CITY OF PORTLAND, MAINE

98 Island Avenue, Peaks Island

8 January 1990

Your application to erect a fire escape has been reviewed and a permit is herewith issued subject to the following requirements:

PLAN FOR LIONEL FLAITS ASSO.
ISLAND AVE. PEAK ISLAND
APPRO. 15'

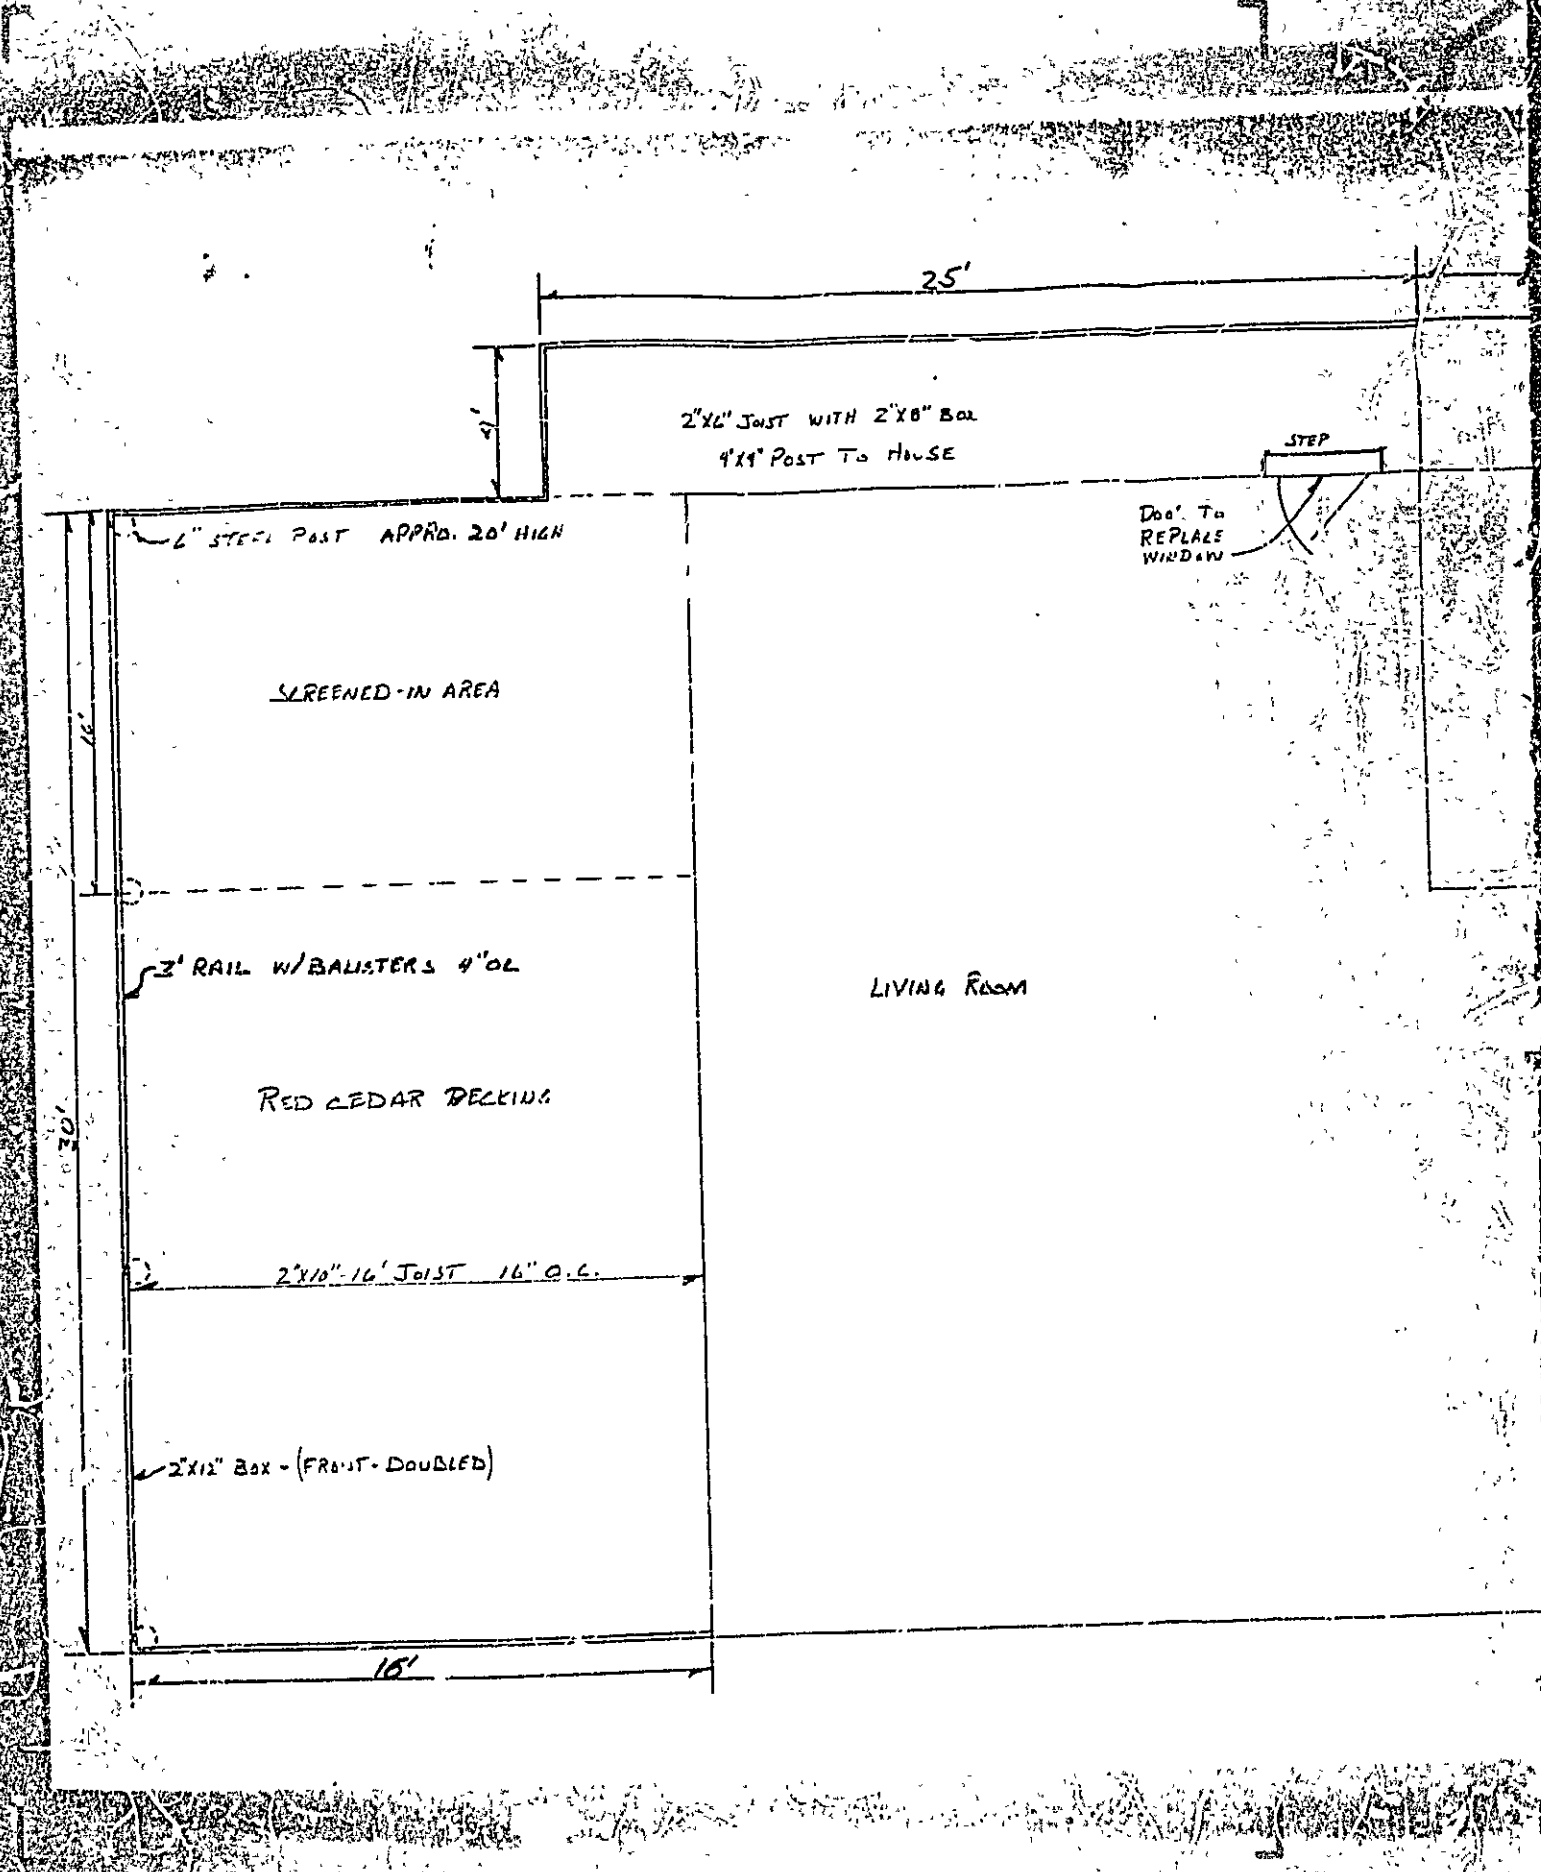
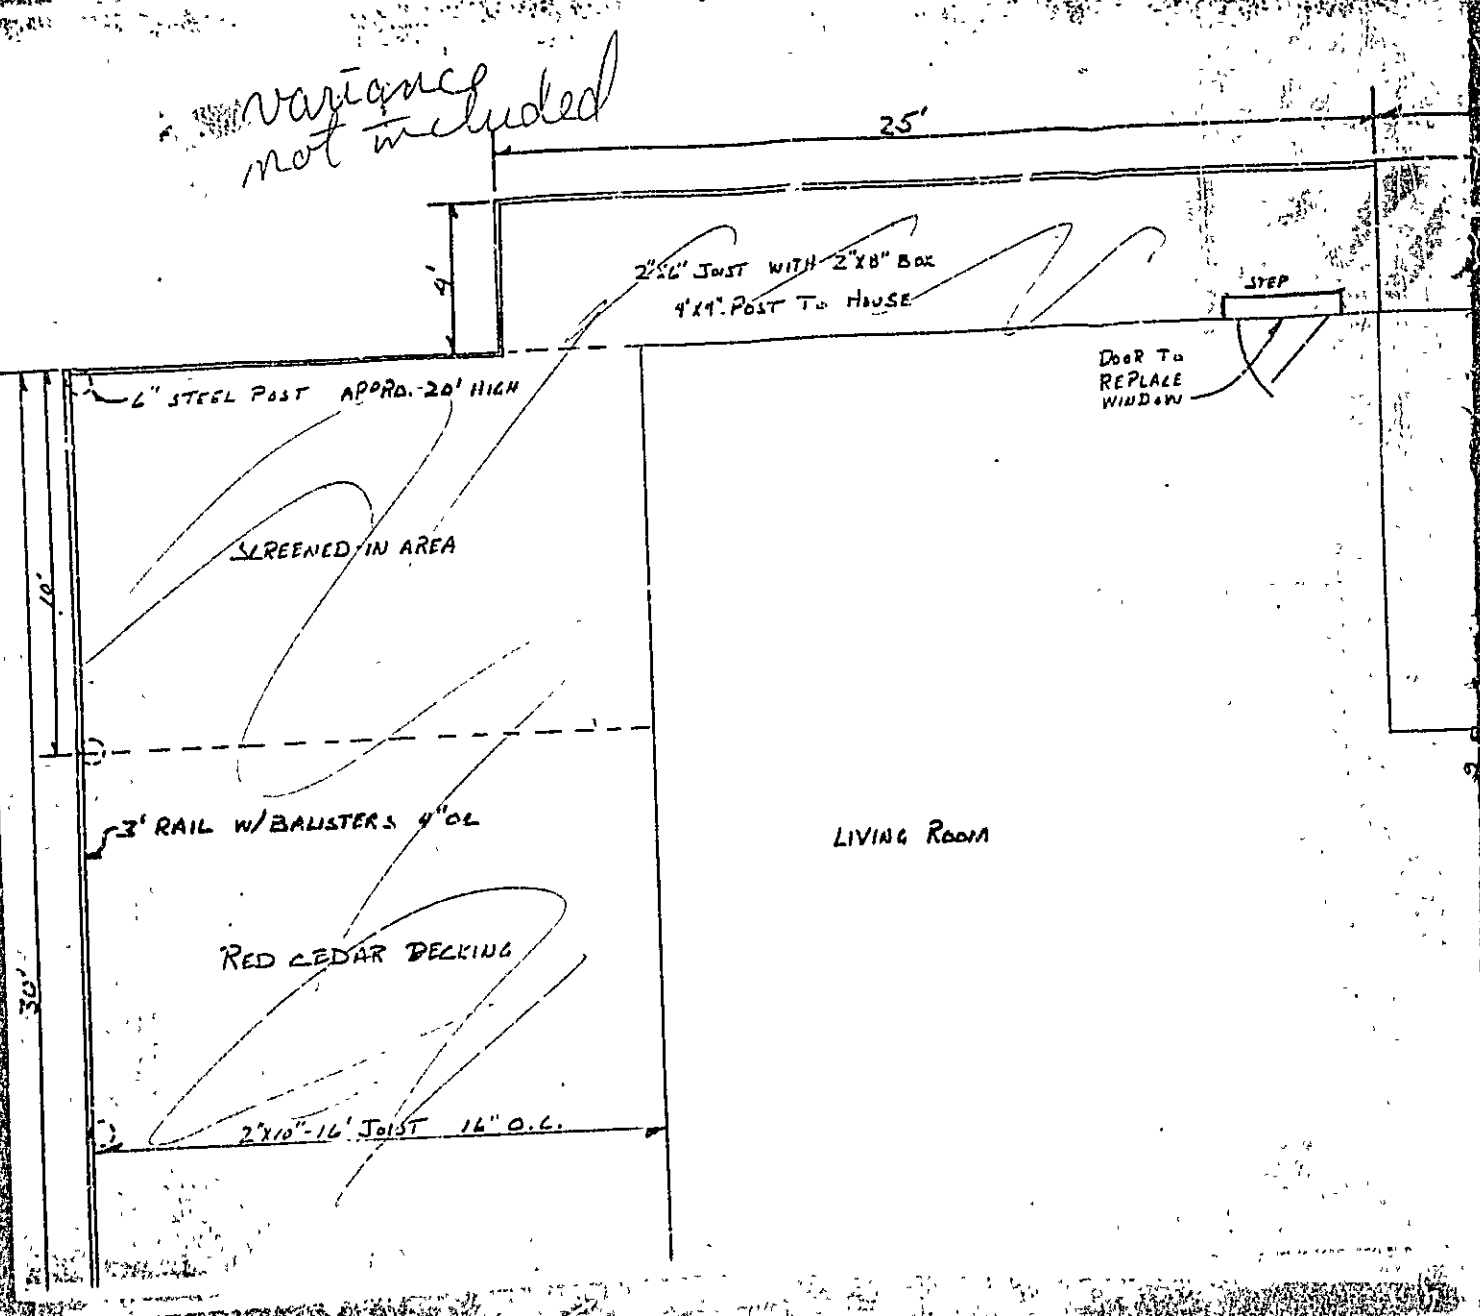
1. The fire escape shall be designed to support a live load of 100 pounds per square foot. Fire escape to be constructed of wood not less than 4" thick.
2. Stairs shall be at least 22" wide with risers not more than 8" and treads not less than 8". Landings at the foot of the stairs shall not be less than 40" wide x 36" long and located not more than 8" below the access window or door.
